**Proposal:** Discharge of Condition 3 (windows & doors) , Condition 5 (timber cladding), and Condition 7 (stone sample panel) of 21/00437/F

- 1.1. The application site is located in a row of detached and semi-detached cottages outside the built-up limits of Sibford Gower. It is within the Sibford Gower and Burdrop Conservation Area and is a Grade II listed building.
- 1.2. Consent was granted under application 21/00437/F for the addition of solar thermal panels under slate tiles for solar-thermal power to the garage, installation of new garage doors, replacement of deteriorated windows in the garage with new double-glazed to match the Main House, the demolition of a dilapidated Log Store and its replacement it with a Garden Room and new timber entrance gates to the driveway

- 2.1. The application is seeking approval for details required by Condition 3 (windows & doors) , Condition 5 (timber cladding), and Condition 7 (stone sample panel) of 21/00437/F

TITLE:  
Door D1

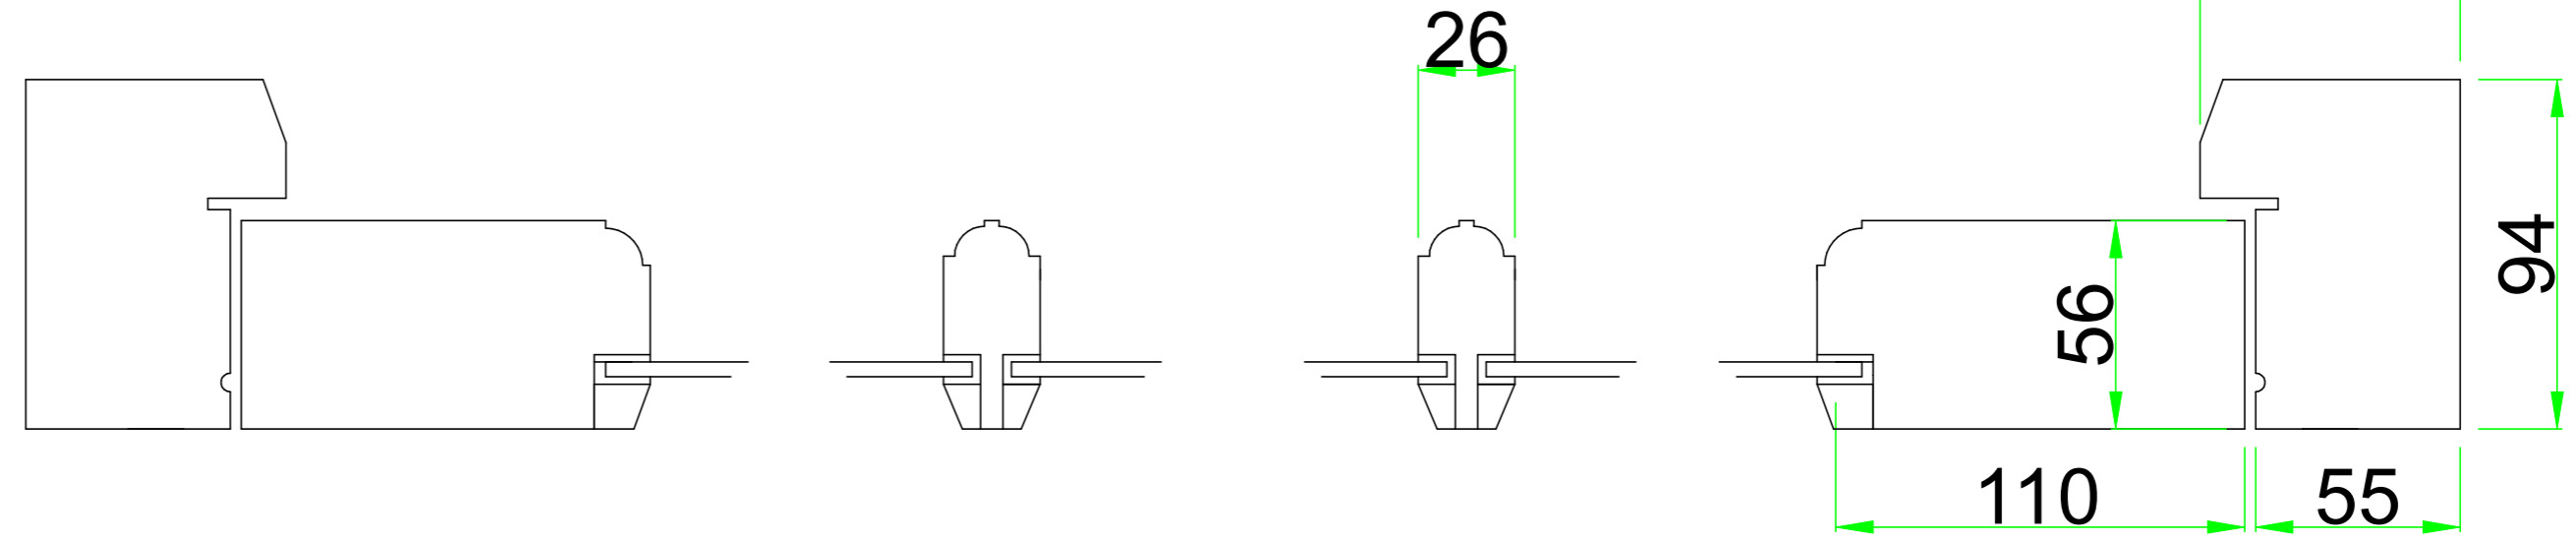
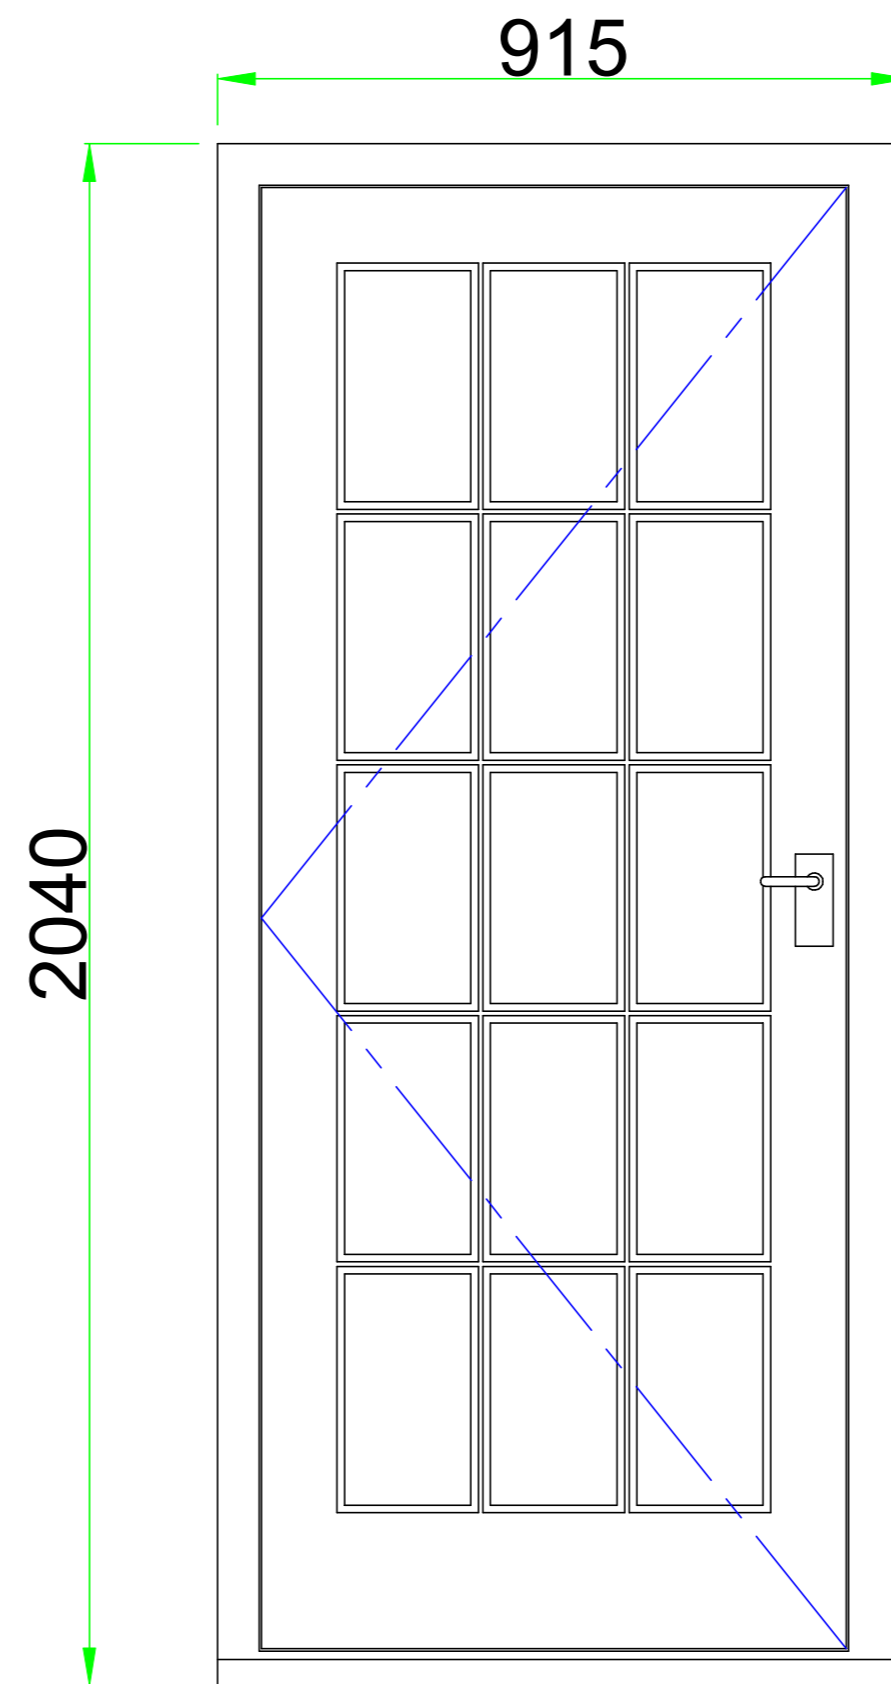
- 4.1. Condition 3 requires the submission and approval of details of new doors and windows, which have been amended during the course of the application in

response to the Conservation Officer's comments. The amended details are considered acceptable. Whilst the small window adjacent to the front door is inappropriate for a listed building due to the leadwork being applied to the glass rather than true leading being used, this is a like for like replacement and as such we cannot seek betterment. Likewise, the proposed front door is not of a detailed design that reflects the character of the building but it too is proposed to be replaced on a like for like basis. The details are considered acceptable.

Drawing Nos: D1, D2, D3, D4 (showing glazed panels without glazing bars), W1 W2 and W3 and Kitchen Window.
